Subject: New comments for application 19/01746/OUT

New comments have been received for application 19/01746/OUT at site address: Land Adj To Promised Land Farm Wendlebury Road Chesterton

Fig. 27 Proposed infrastructure plan, DTA drg no 19539—11—12 Wendlebury Road Site Access Roundabout

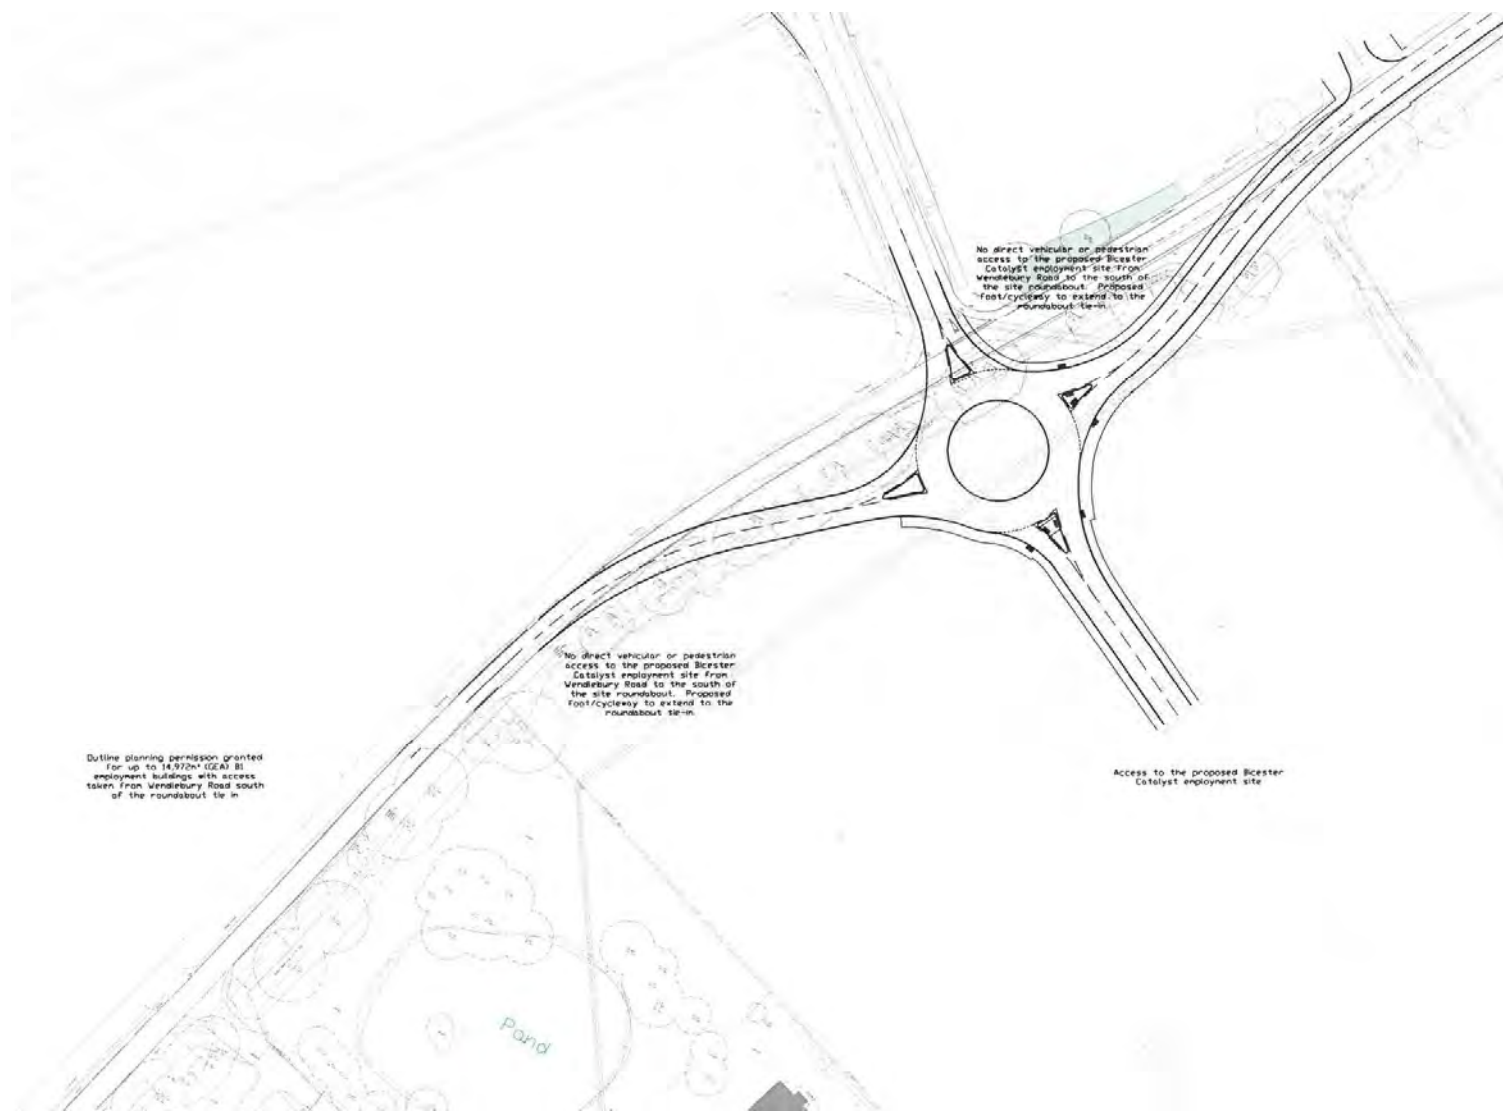
C. CYCLE PROTECTION ON NEW ROUNDABOUT

The addition of a new roundabout will provide an obstacle to pedestrian and bike usage. This could be ameliorated by designing it in accordance with 'Dutch' standards, ie to angle lanes to reduce entry speeds, and to include a segregated cycle path.
